WEST SUSSEX COUNTY COUNCIL CONSULTATION

TO:	Arun District Council FAO: Mr. S. Davis
FROM:	WSCC – Highway Authority
DATE:	23 April 2026
LOCATION:	Tesco Superstore Shripney Road Bognor Regis PO22 9ND
SUBJECT:	BR/24/26/PL Installation of single storey raised car park deck together with site alterations, car park reconfiguration, new access into car park, drainage alterations, creation of new drainage outfall, landscaping and other associated works. Additional transport technical note received.
DATE OF SITE VISIT:	9 March 2026
RECOMMENDATION:	More Information Required

This is the second WSCC Highways response to the above planning application proposing installation of single storey raised car park deck together with site alterations, car park reconfiguration, new access into car park, drainage alterations, creation of new drainage outfall, landscaping and other associated works.

Comments below specifically respond to Technical Note prepared by Transport Planning Associates (TPA), reference 2501-044/TN/01 – April 2026.

Proposed ground floor plan. NTS

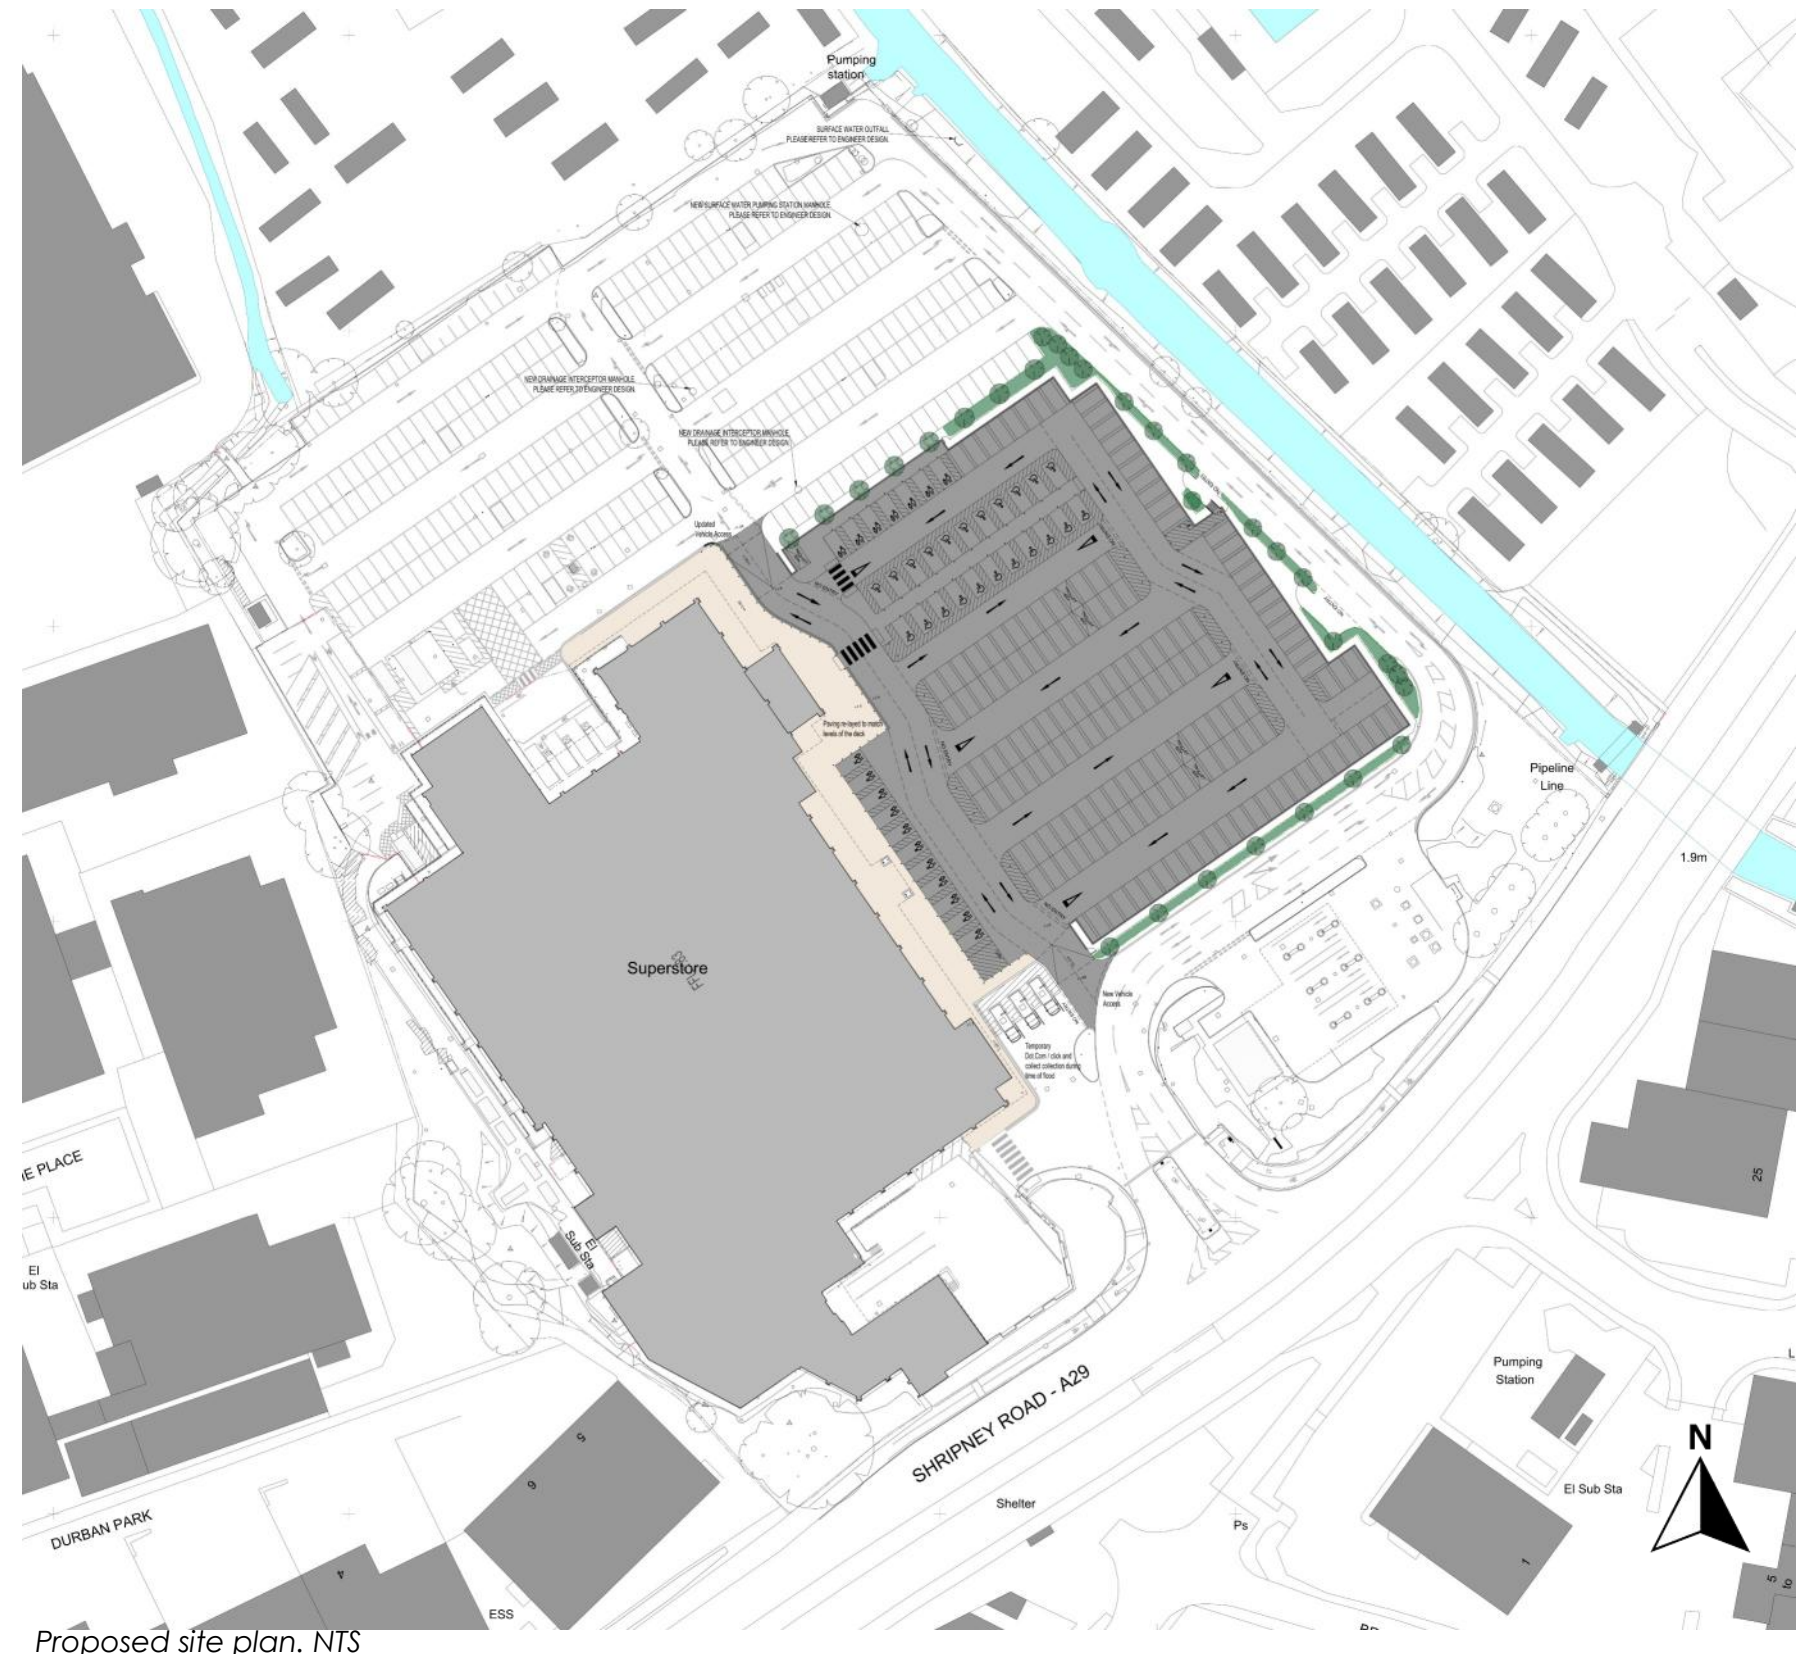
3. Access for mobility-impaired users – Access for mobility impaired users does not appear to be demonstrated (e.g. Only steps up and down to and from the raised deck appear to be shown but other than the vehicle access ramps, no bespoke ramps appear on the plans). Applicant to provide plans.

4. Bus access – The existing bus waiting area is shown removed from the site and replaced with temporary 'dot-com' collection and delivery bays. This would be a retrograde step for those users wishing to get to the site by public transport. Therefore, the Highway Authority recommends that it remains and another location found for the temporary 'dot-com' delivery vehicles.

The proposed parking deck will be level with the footway that runs along the front (eastern side) of the store, only rising above the existing ground level as it extends to the east. Level access for mobility impaired customers will therefore be provided from the deck and from Shripney Road. New dropped kerbs for pedestrian access from the existing car park areas to the north of the store will be provided along the north side of the store.

Disabled parking bays are positioned closest to the site frontage/entrance to minimise travel distances from vehicles to store entrance points. A copy of the updated site plan, with level access areas indicated is provided at Appendix B. Step-free access is provided via designed accessible routes (as indicated by blue arrows on the proposed layout). Areas marked as non-accessible (red outline) reflect level changes associated with the raised deck.
